ECE Planning Ltd
Brooklyn Chambers
11 Goring Road
Worthing
BN12 4AP

Our Ref: A/165/19/DOC

Approval of details reserved by condition imposed under ref A/74/18/OUT relating to Condition Nos 4 - acoustic, 5 - external lighting, 7 - contamination, 12 - hedgerows, 14 - surface water drainage, 15 - discharge of flows, 16 - SuDs and 18 - watercourse or culvert.

The Laurels Dappers Lane Angmering BN16 4EN

**Project:** Oceanview Developments  
**The Laurels**  
Dappers Lane  
Angmering  
**Title:** Proposed Drainage Strategy Plan

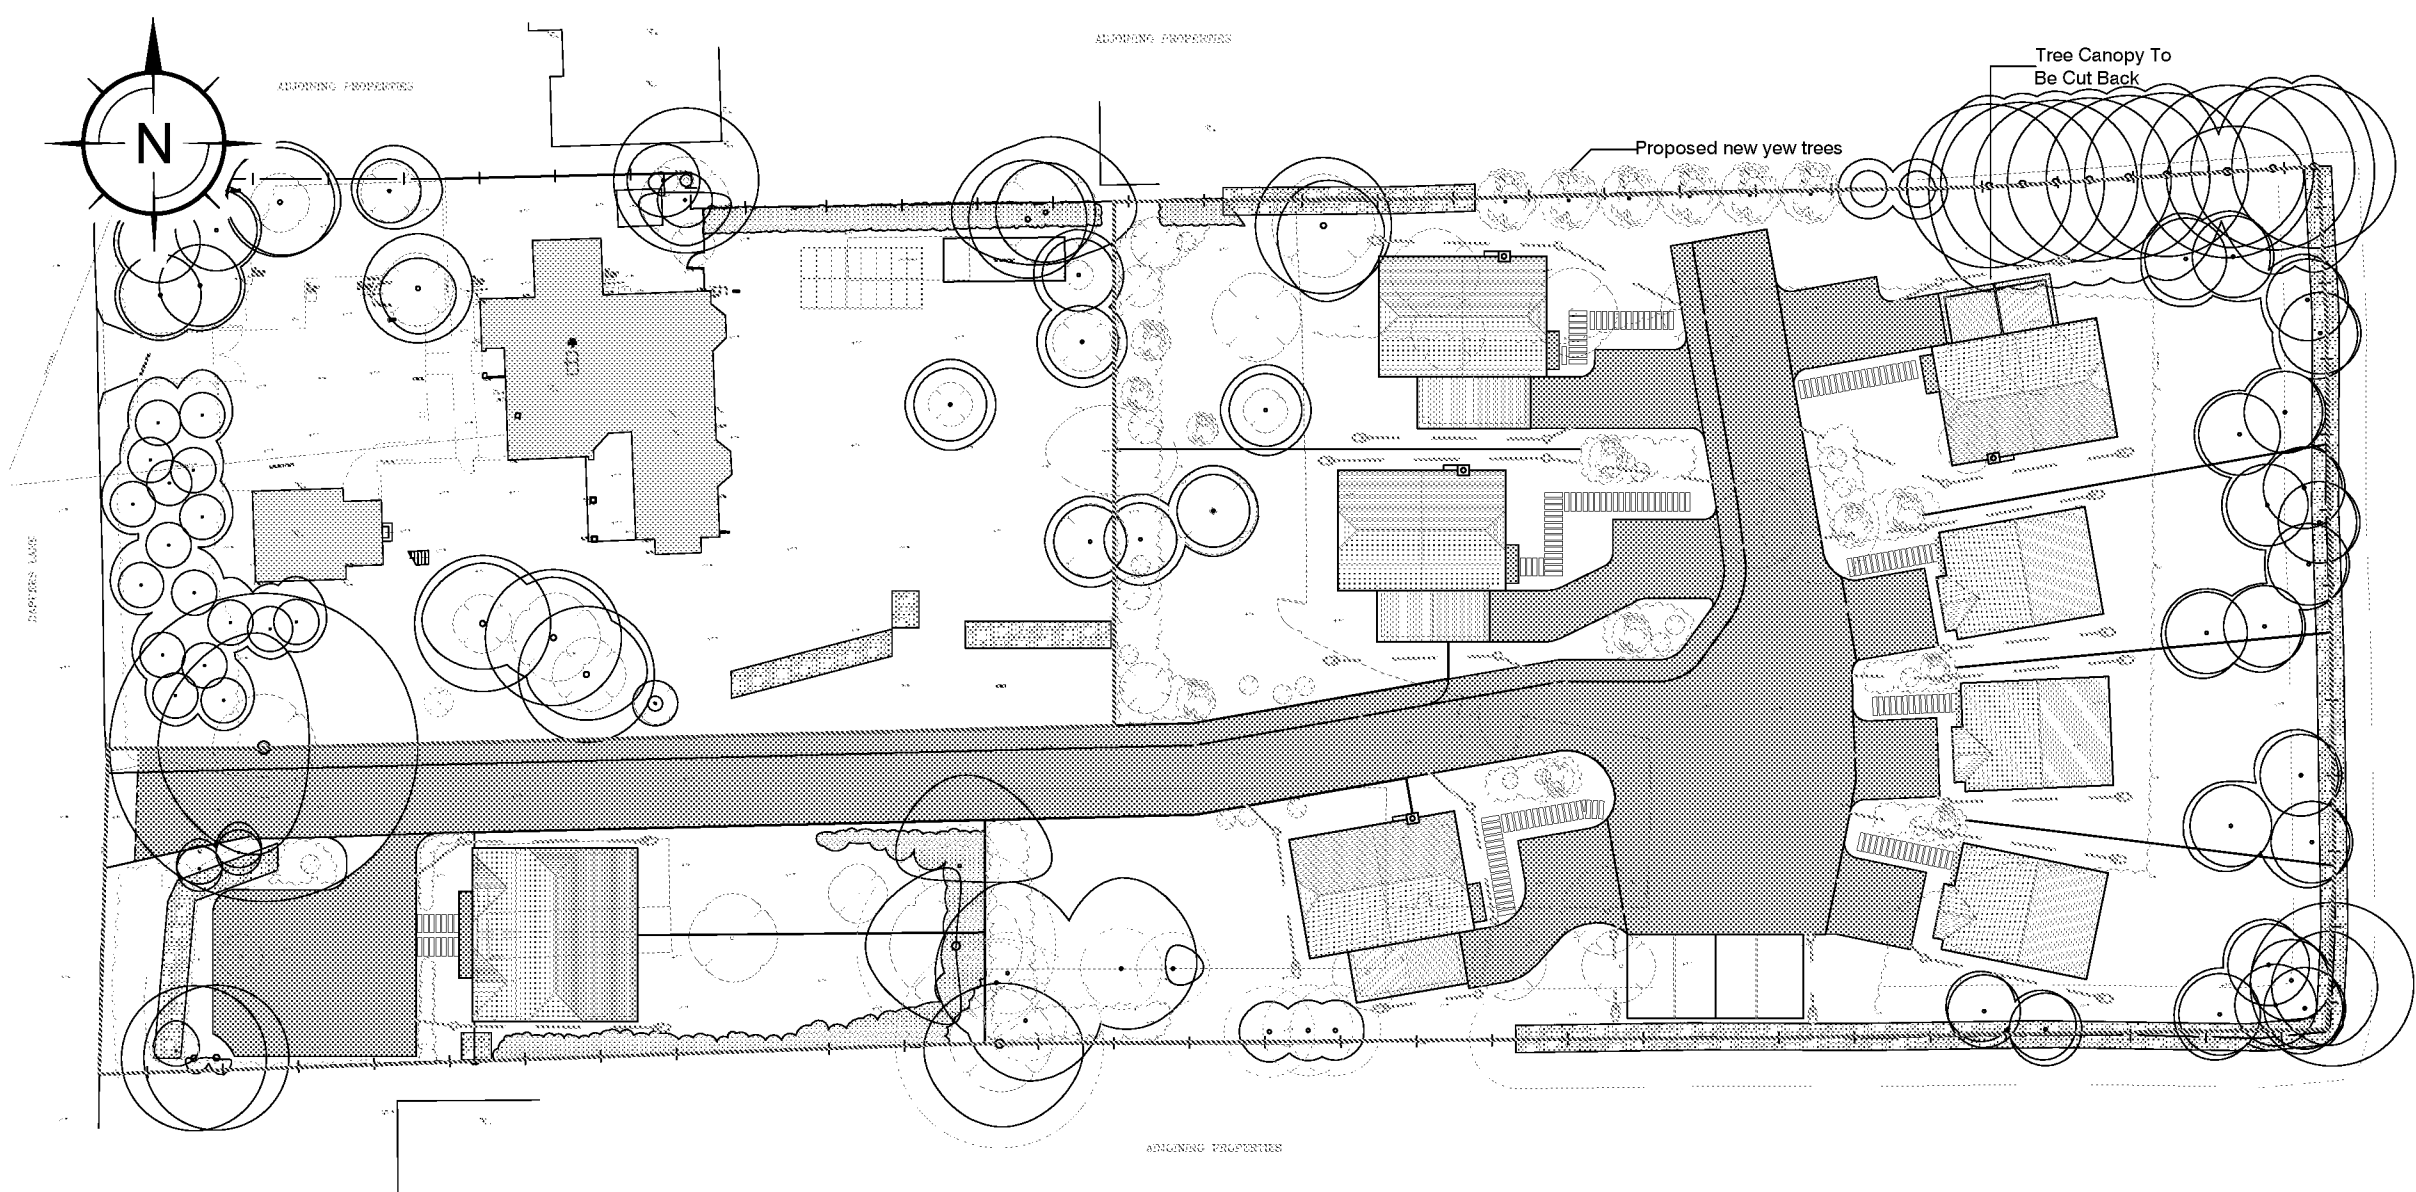
The applicant appears unaware that a culverted watercourse that runs along the western boundary, The following details should be provided so further comments can be made;

- A plan showing its location.
- Position/photos of any existing manholes on the culvert adjacent the site including immediately upstream/downstream.
- Manhole/culvert invert levels/cover levels.
- Pipe diameter/material.

- e) An internal CCTV survey inspection.
 - f) Proposed finished levels above the culvert.
 - g) No new tree planting to be undertaken in the vicinity of the culvert. This needs to be made clear on the drawings.

5. Whilst permeable paving is likely to be the way forward, due to the lie of the land, the design will need to ensure that water does not all run to the lower end of the site via the sub base, so the paving will need to be compartmented to ensure that water is contained within each structure. This arrangement will need to be fully detailed in terms of construction details and proposed finished/bed levels and supported by storage/infiltration calculations for each section. Please note that on the example calculation sheets, a porosity value of 0.95 has been used. Whilst this is acceptable for permavoid blocks, granular stone should be 30%, so the calculations will need to reflect the construction of each specific section of permeable paving. Where stone is to be used, this is to be type 3 material (of specified grading/no fines) wrapped in a permeable membrane.

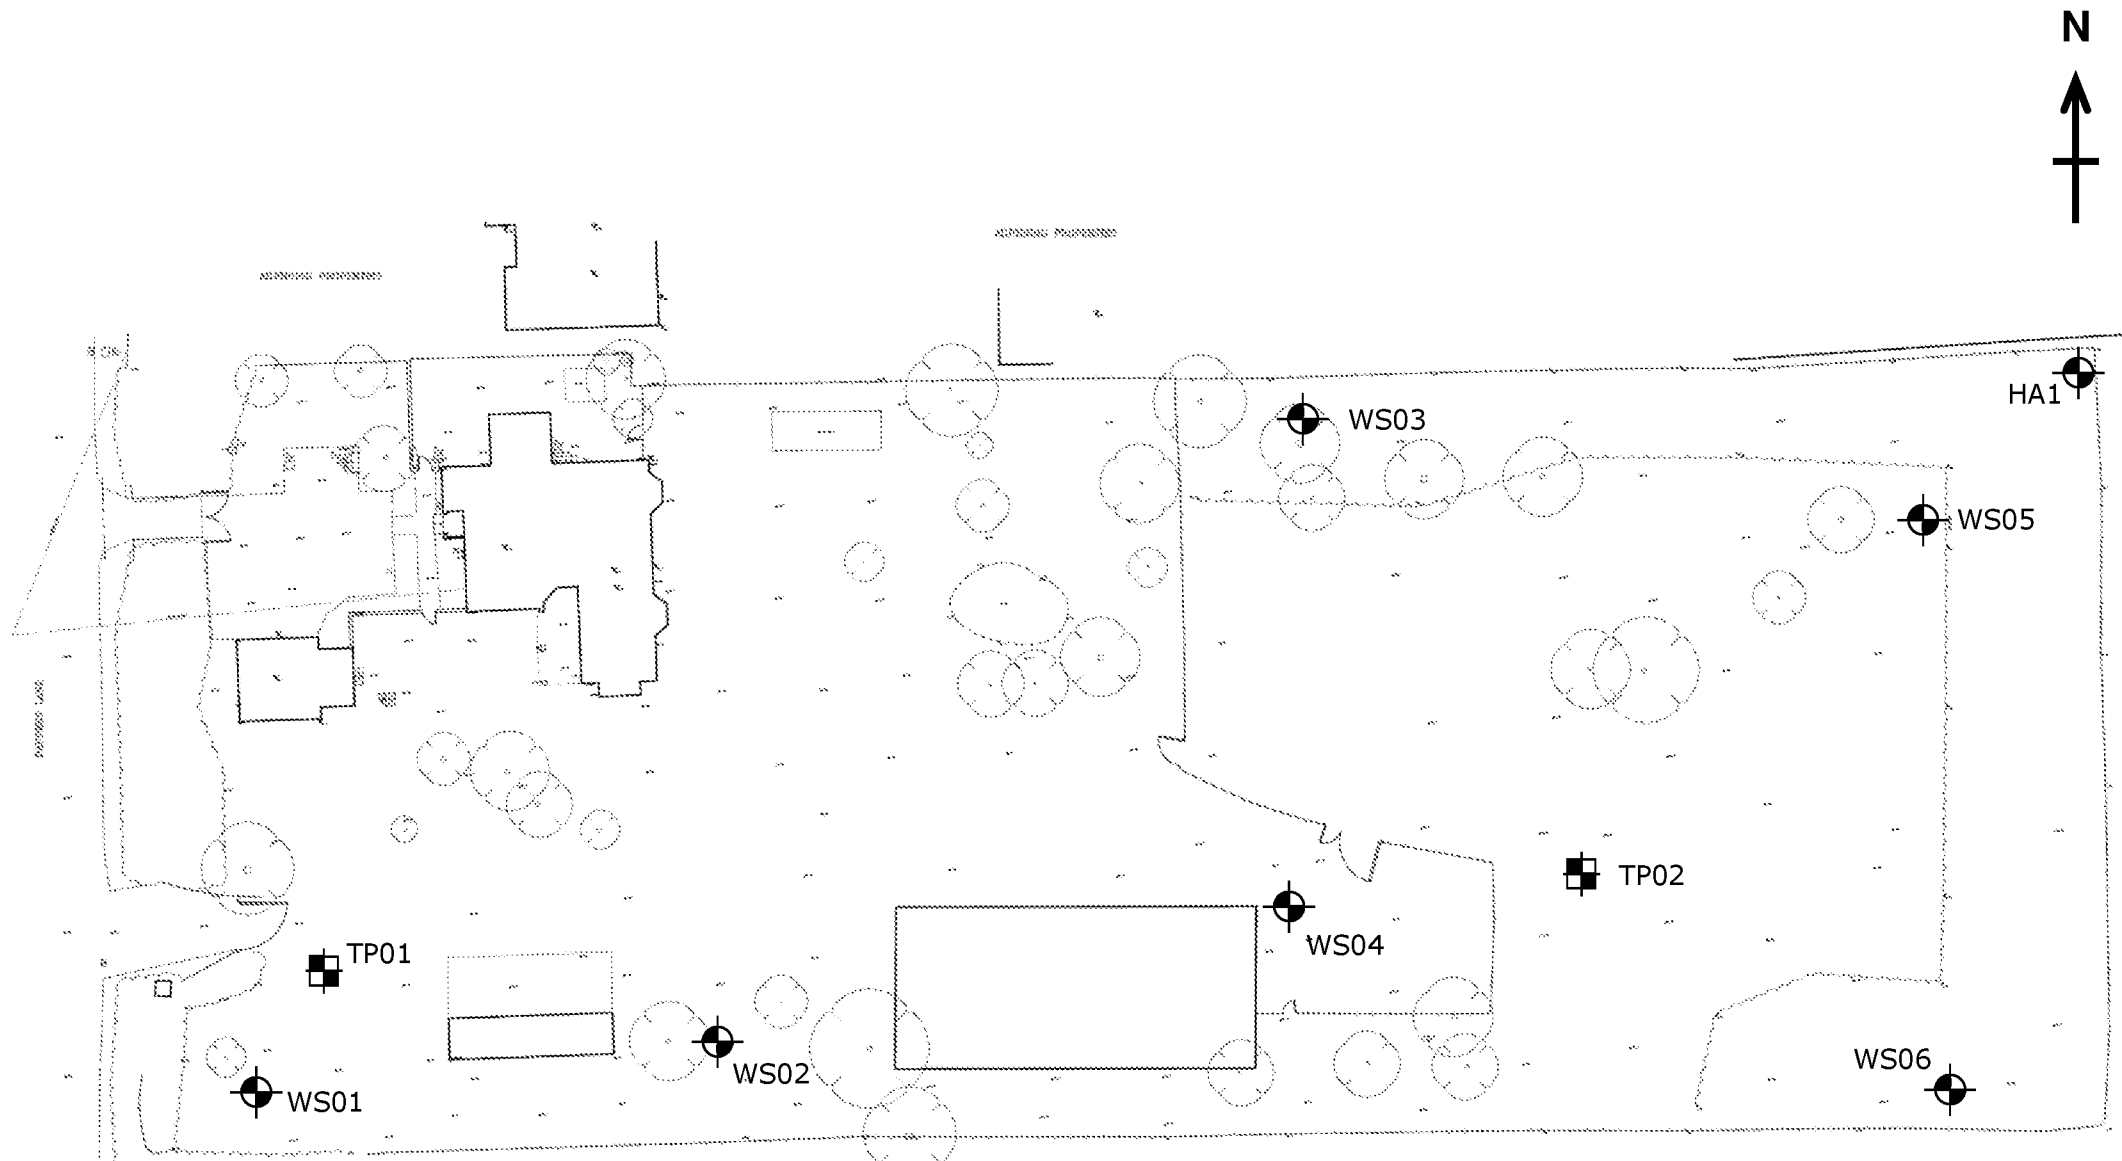
4. The percolation testing was carried out in October 2018 which does not fulfil our requirements in terms of winter testing. Therefore, further infiltration testing will be required, in say January, at the location and depth of the proposed infiltration structures. These must be in strict accordance with BRE365.

- Undertaking testing within boreholes does not meet this criteria. It is noted that TP02 failed to infiltrate sufficiently, so more detailed investigations/testing will be required in that area. It is strongly recommended that the applicant agrees the location/depth of the test holes, before actioning. Until such time that items 3 and 4 have been resolved, it is not possible to comment in any great detail on the proposals. Some suggested requirements below need to be considered;
